**Consultation Response from Emma Mills,
KC Landscape**

Planning Number: 2020/92350

Proposal: Outline application for residential development (Use Class C3) of up to 181 dwellings, Land south of, Heybeck Lane, Chidswell, Shaw Cross, Dewsbury

Date Responded: 16.11.20

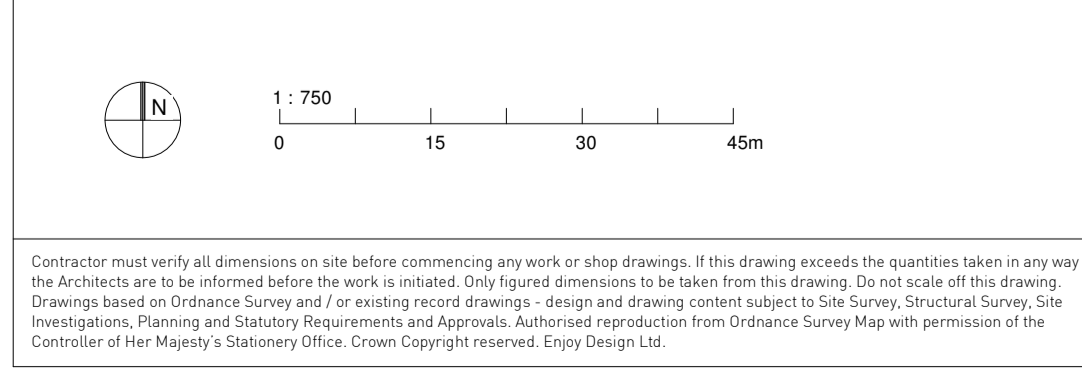
Unfortunately the points raised in the strategic landscape framework and the proposed mitigation have not been realised in the Strategic Landscape Framework plan with barely any street tree planting indicated.

The Council considers a presumption in favour of tree planting in verges and adjacent to carriageways in line with the West Yorkshire Combined Authority 'Green Streets ®' principles, unless there are valid reasons for their omission. We are surprised at the minimal street tree planting – this will need to be addressed. Refer to points 2 and 3 below.

There is very little landscape information submitted in order to be able to comment. Mitigative planting and landscape concept information should be provided on the initial landscape proposals as a minimum for maintaining and enhancing existing vegetation, details of multi-functionality such as integrated SuDS.

Details of purpose and design of the pos area and accessibility and connectivity is key at the outline stage and should be provided to demonstrate they are well connected throughout the scheme and to beyond its boundaries, given the semi-rural location.

2. The Council considers a presumption in favour of tree planting in verges and adjacent to carriageways in line with the West Yorkshire Combined Authority 'Green Streets ®' principles, unless there are valid reasons for their omission. Tree planting is very important, and getting the right types and size of trees in the right places is imperative. Trees should be incorporated in the scheme for a variety of reasons: to a] visually break up the built form b] help to screen/ mitigate or frame certain views c] support biodiversity and create green corridors/green links, d] not to create a nuisance in peoples gardens through leaves in gutters or screen the sun etc. e] not to cause damage to property boundaries/garden fences/dry stone walls in the future, or damage any SuDS system. There are opportunities for tree planting within the site and this will help mitigate the scheme. That being said, careful design is required. Trees should be incorporated into the street where possible but when necessary in gardens, not being located too close to buildings.
